PEDESTRIAN WIND ENVIRONMENT STATEMENT
HURLSTONE AGRICULTURAL HIGH SCHOOL
(HAWKESBURY)

WD849-01F02(REV0)- WS REPORT

12 SEPTEMBER 2017

DRAWING
Level 01 GA

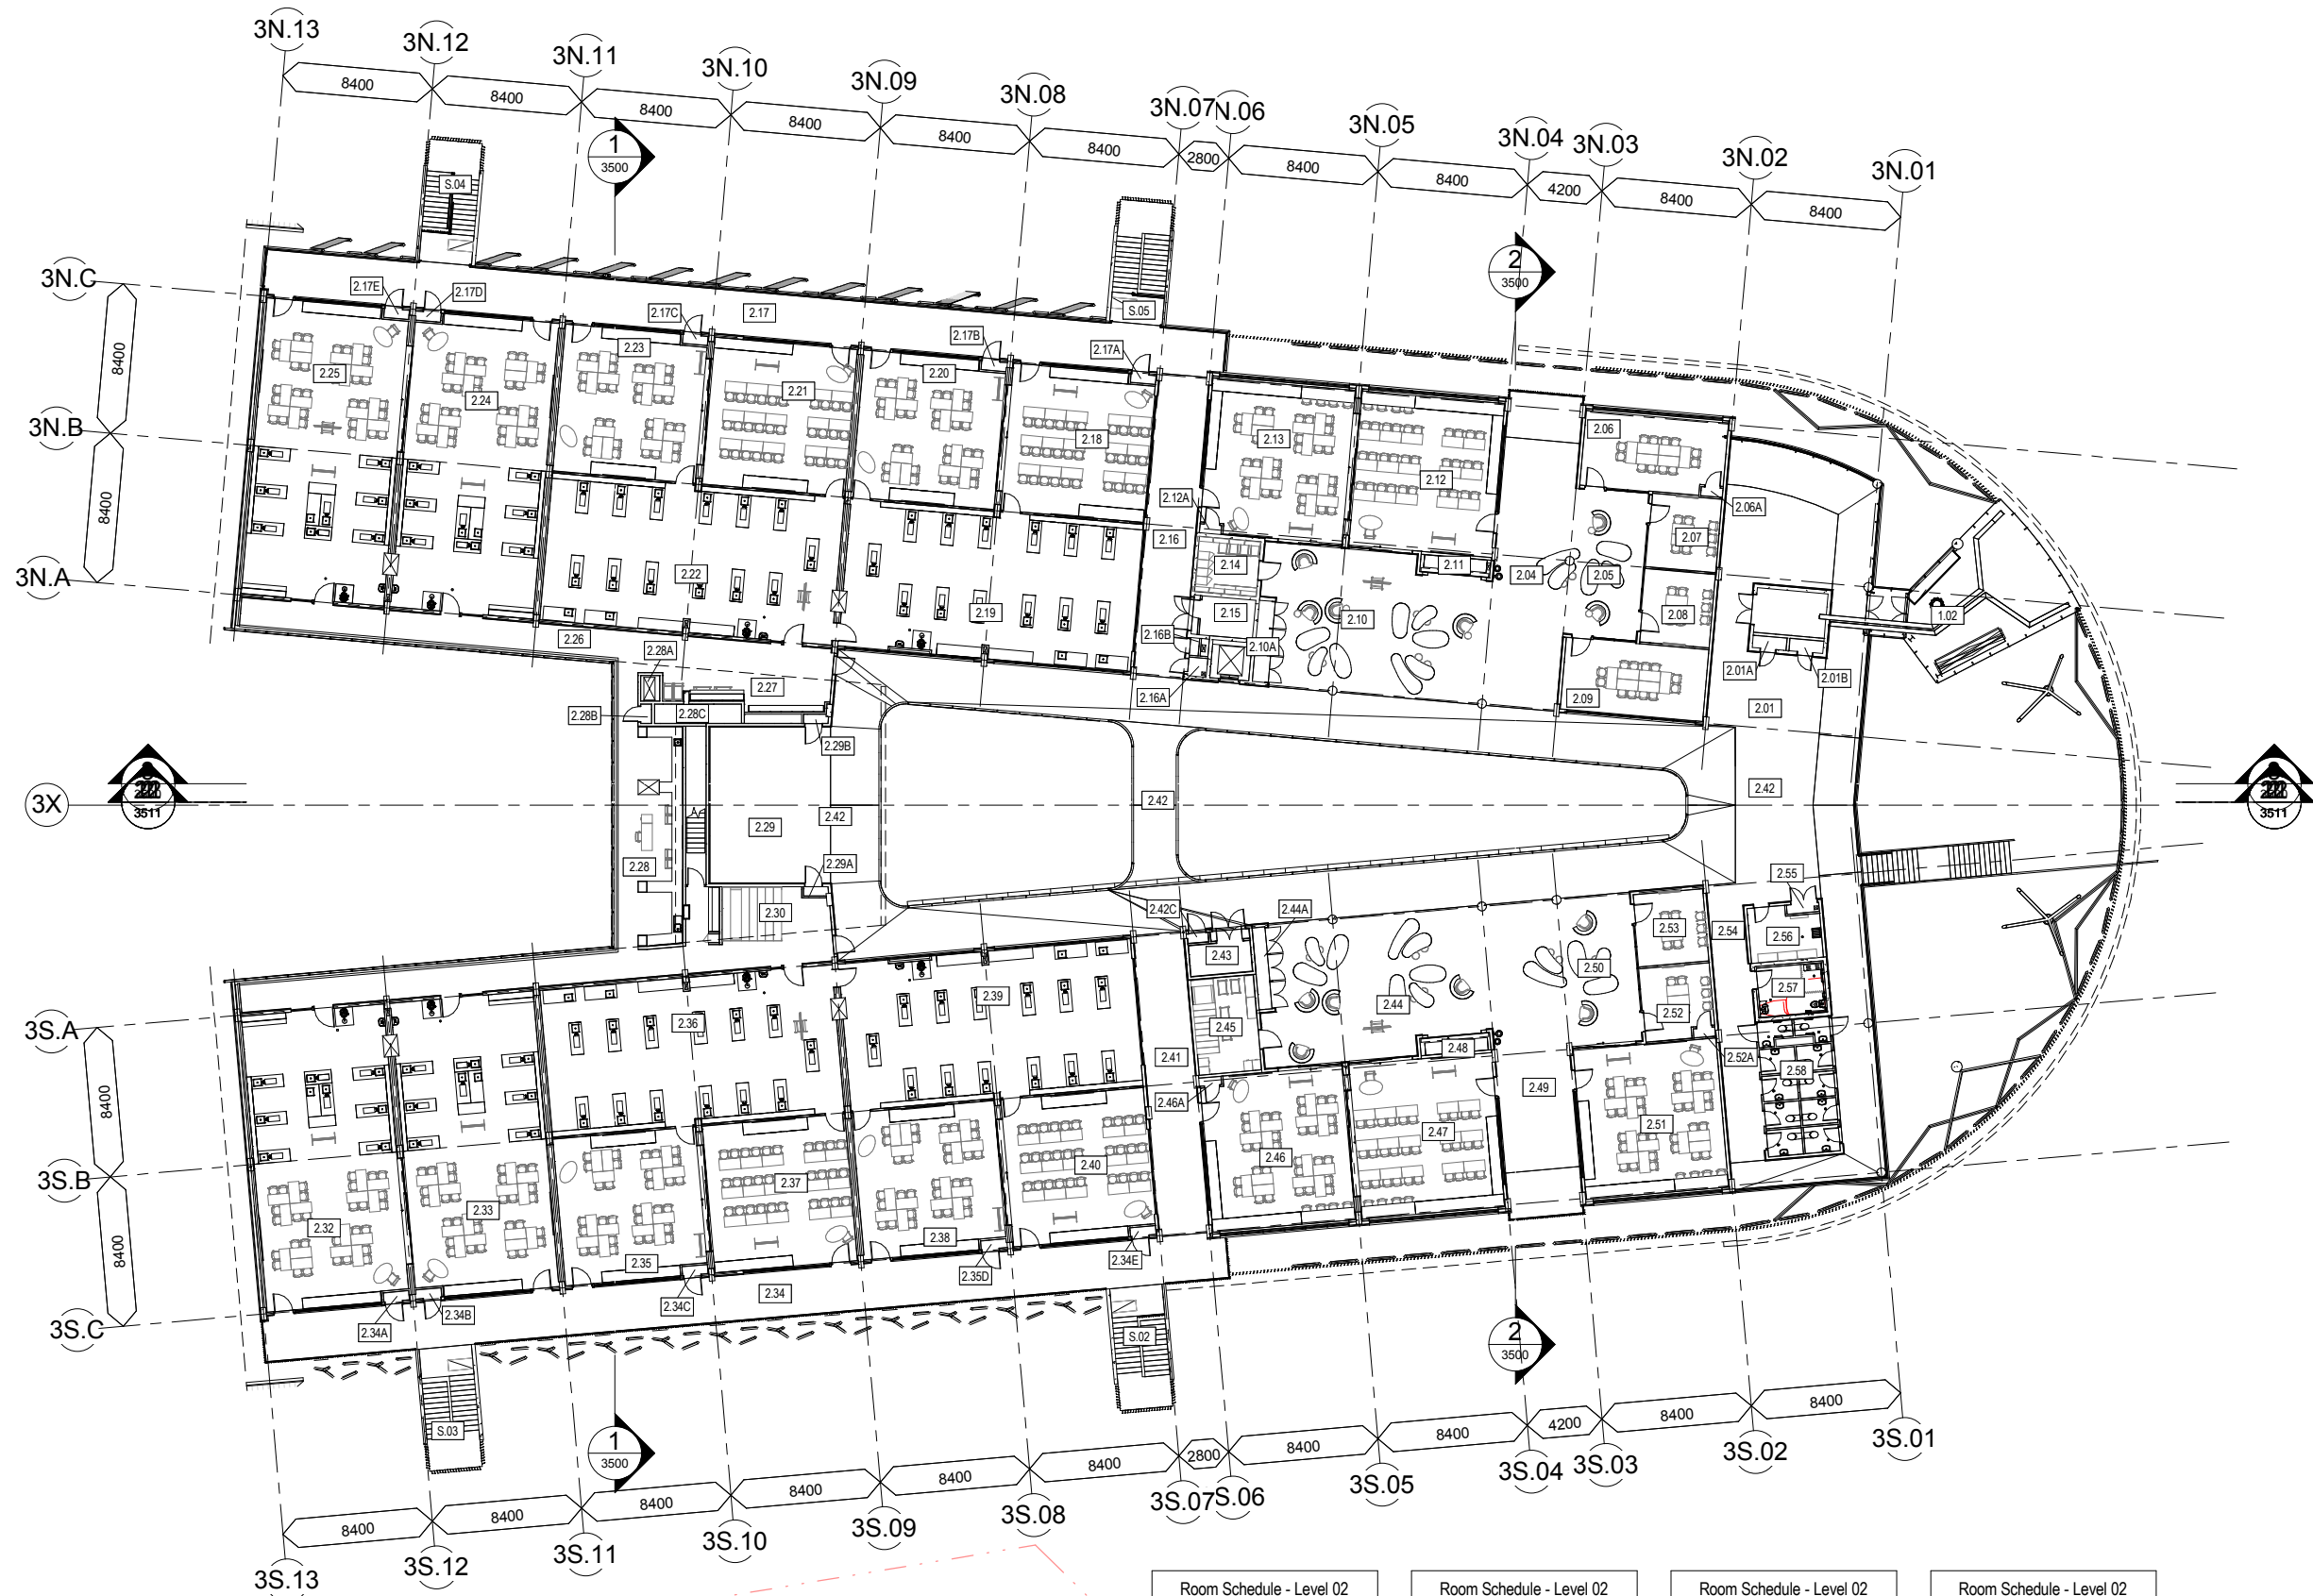
The circulation areas on Levels 01 and 02 of Building 03 are prone to adverse wind conditions as a result of the direct impact of the westerly winds. Similarly the circulation areas on Level 02 of Building 02 are prone to adverse wind conditions due to the direct impact of the southerly winds. To mitigate these adverse wind conditions, it is recommended that the proposed impermeable screen on the southern aspect of Level 02 of Building 02 be retained in the final design of the development, as indicated in Figure 3e. Furthermore, to mitigate the adverse wind conditions for the circulation areas on Levels 01 and 02 of Building 03, it is recommended that the proposed impermeable balustrades on the north-western and south-western corners of Levels 01 and 02 of Building 03 be retained in the final design of the development, as indicated in Figures 2d and 2e.

- Retain the proposed impermeable balustrades on the Outdoor Roof Garden of Building 01 in the final design of the development.
- Include some densely foliating evergreen foliage throughout the Outdoor Roof Garden of Building 01.
- Include 2m high impermeable screens on the southern and western aspects of the Central Ring Walkway.
- Retain the proposed impermeable balustrades on the remainder of the aspects on the Central Ring Walkway in the final design of the development.
- Retain the proposed impermeable balustrades on the south-western and north-western corners of Level 01 of Building 03 in the final design of the development.
